From: Peart, Timothy - Communities <Timothy.Peart@Oxfordshire.gov.uk>  
Sent: 05 November 2019 15:35  
To: George Smith  
Cc: Councillor Lawrie Stratford; DC Support  
Subject: 19/02075/F - The Old Vicarage Fringford Road Caversfield OX27 8TH

<b>Planning application:</b>	19/02075/F
<b>Location:</b>	The Old Vicarage Fringford Road Caversfield OX27 8TH
<b>Description:</b>	Erection of 4 No dwelling houses with associated garages, access and landscaping
<b>Type:</b>	Full Development
<b>Case Officer:</b>	George Smith

Oxfordshire County Council, as the Local Highways Authority, hereby notify the District Planning Authority that they **object** to the granting of planning permission.

Site Plan
AS PROPOSED
Scale 1:200

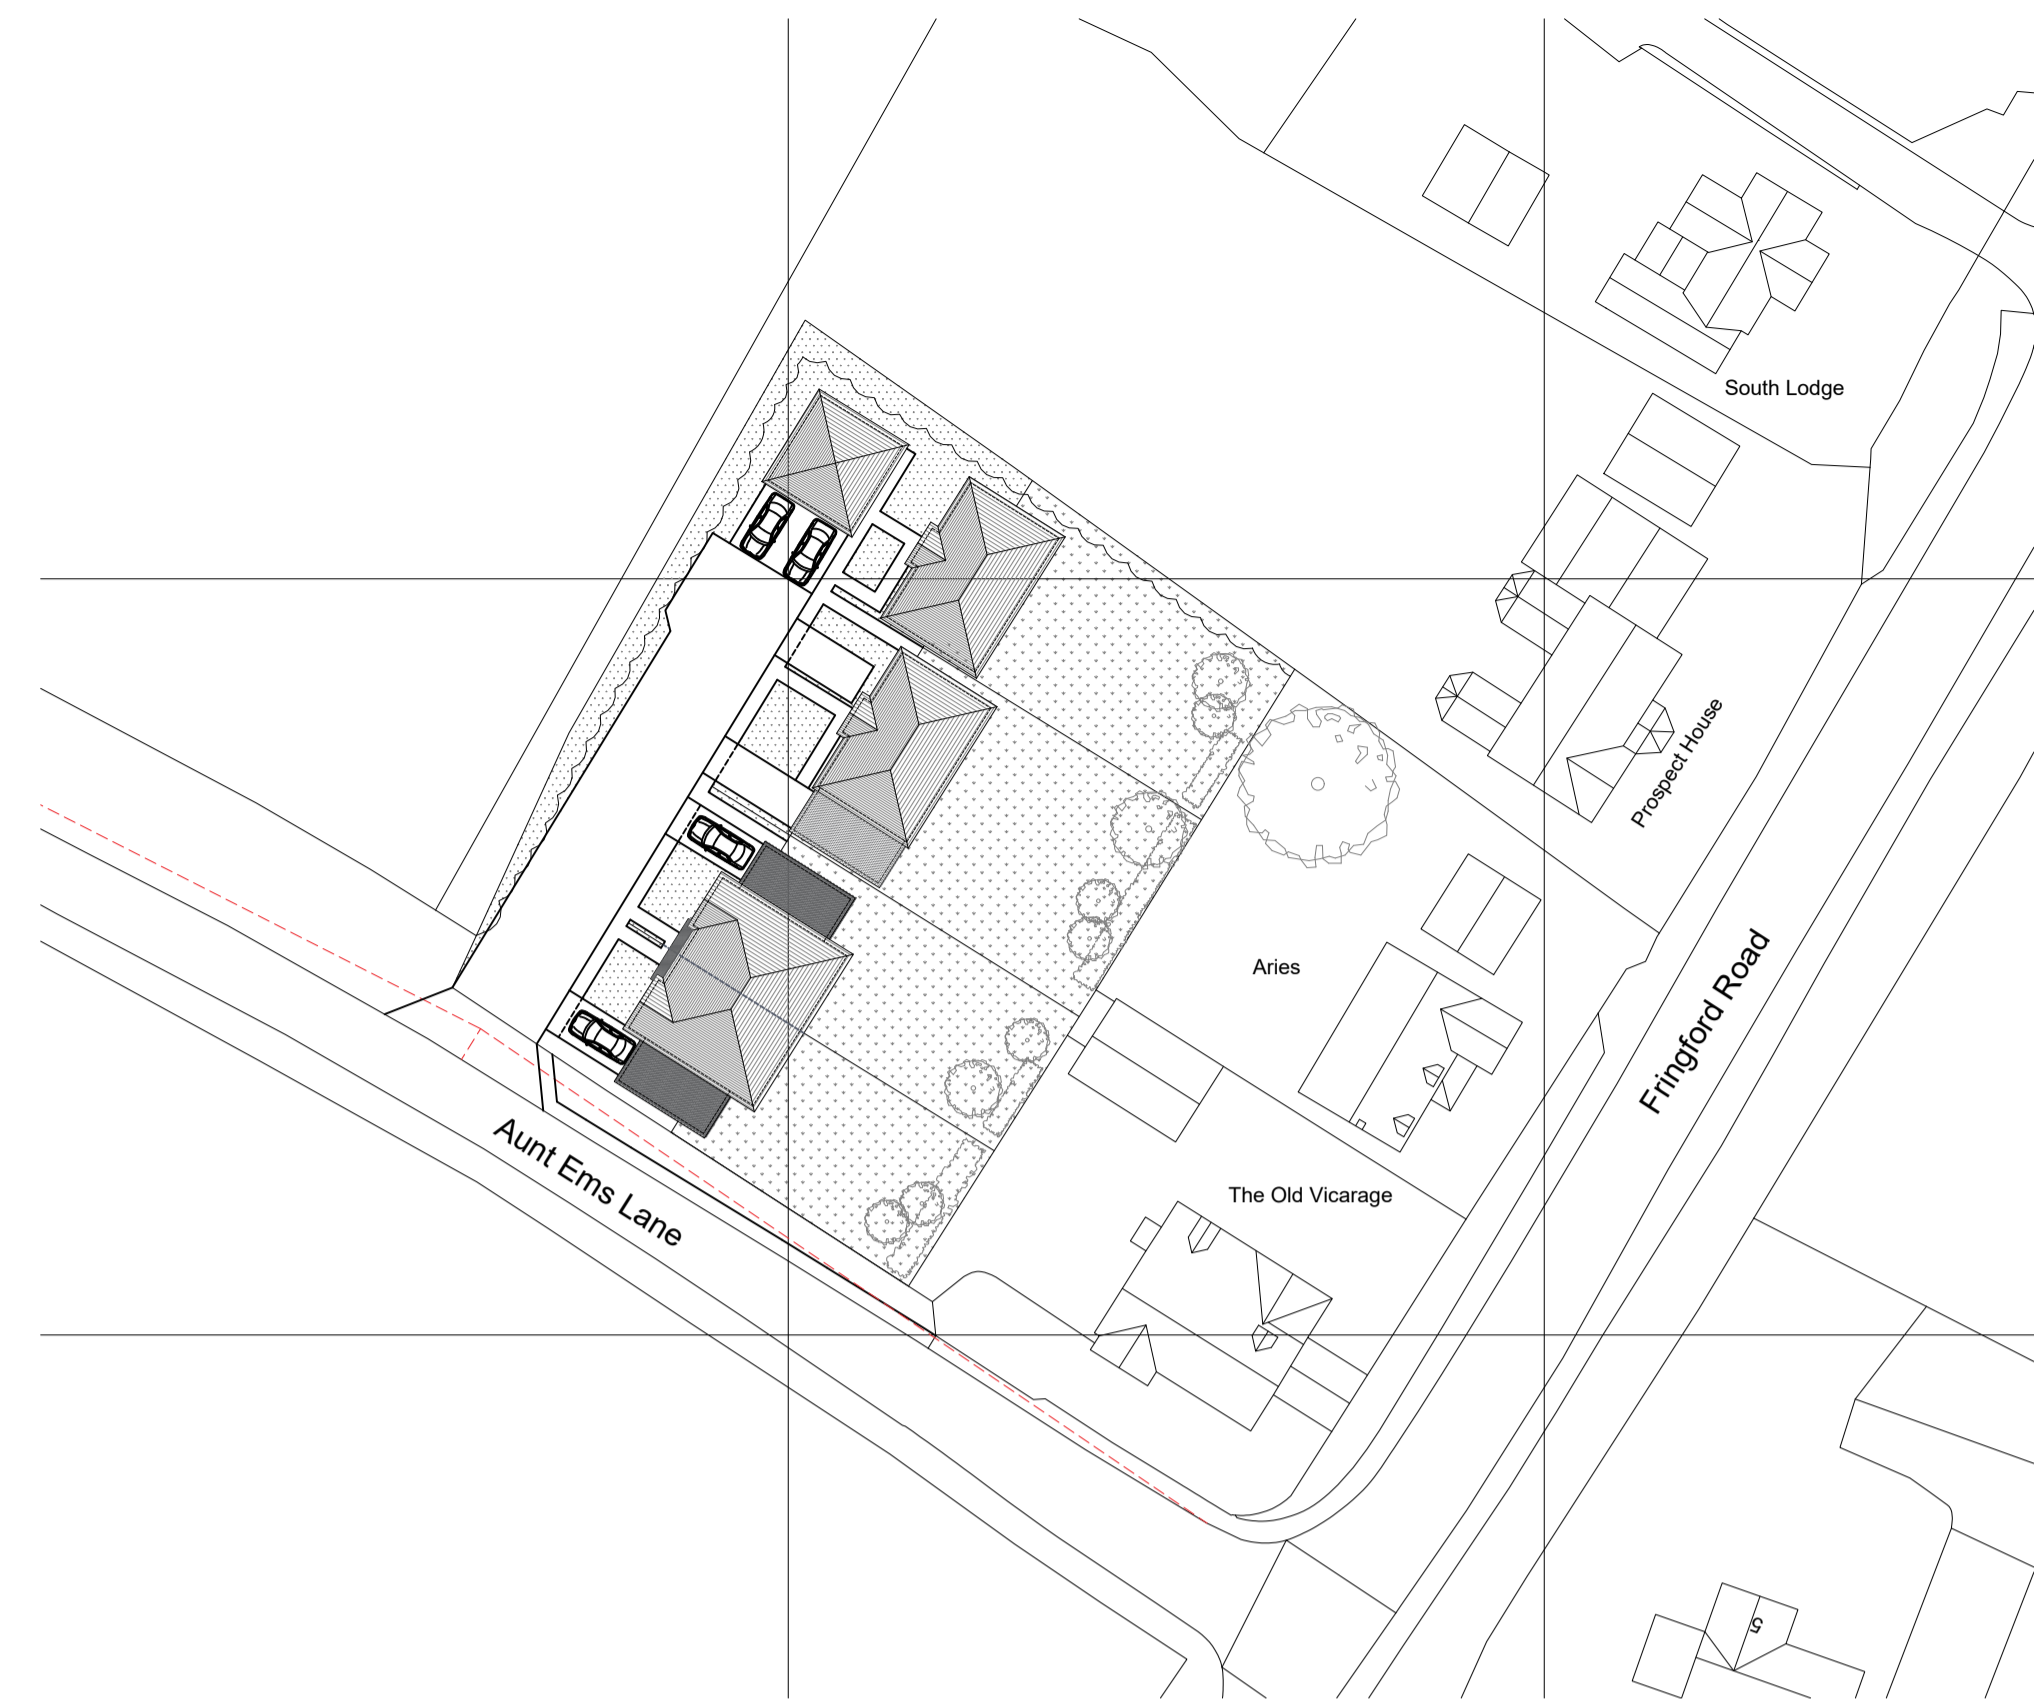
Access is proposed to be taken from Aunt Ems Lane, just inside the 40mph speed restriction zone. It is likely that vehicles approaching from the west would exceed 40mph in the location of the proposed access as they enter the 40mph stretch.

The site layout plan does not show the full extent of the visibility splay to the west of the site access, nor does it indicate the dimensions of the visibility splay. The length of splay required to the west must be based on a speed survey at the location of the proposed site access and the visibility splay cannot extend over third party land. It may be possible to achieve the required visibility splay within the highway boundary however the current application has not demonstrated this. On this basis the county council must object to the application as it currently stands.

Notwithstanding the above, a Section 278 Agreement would be required in order to undertake the required alterations to the highway, including the site access junction, connecting footway, relocation of existing road signs and clearance of vegetation for improved visibility. Should permission be granted a condition is requested to secure these works.

Prior to the commencement of the development hereby approved, full details of the means of access between the land and the highway, including, position, layout, construction, drainage, vision splays (to be informed by speed surveys at the location of the site access) and footways connecting with the existing provision on Aunt Ems Lane shall be submitted to and approved in writing by the Local Planning Authority. Thereafter, the means of access shall be constructed and retained in accordance with the approved details.
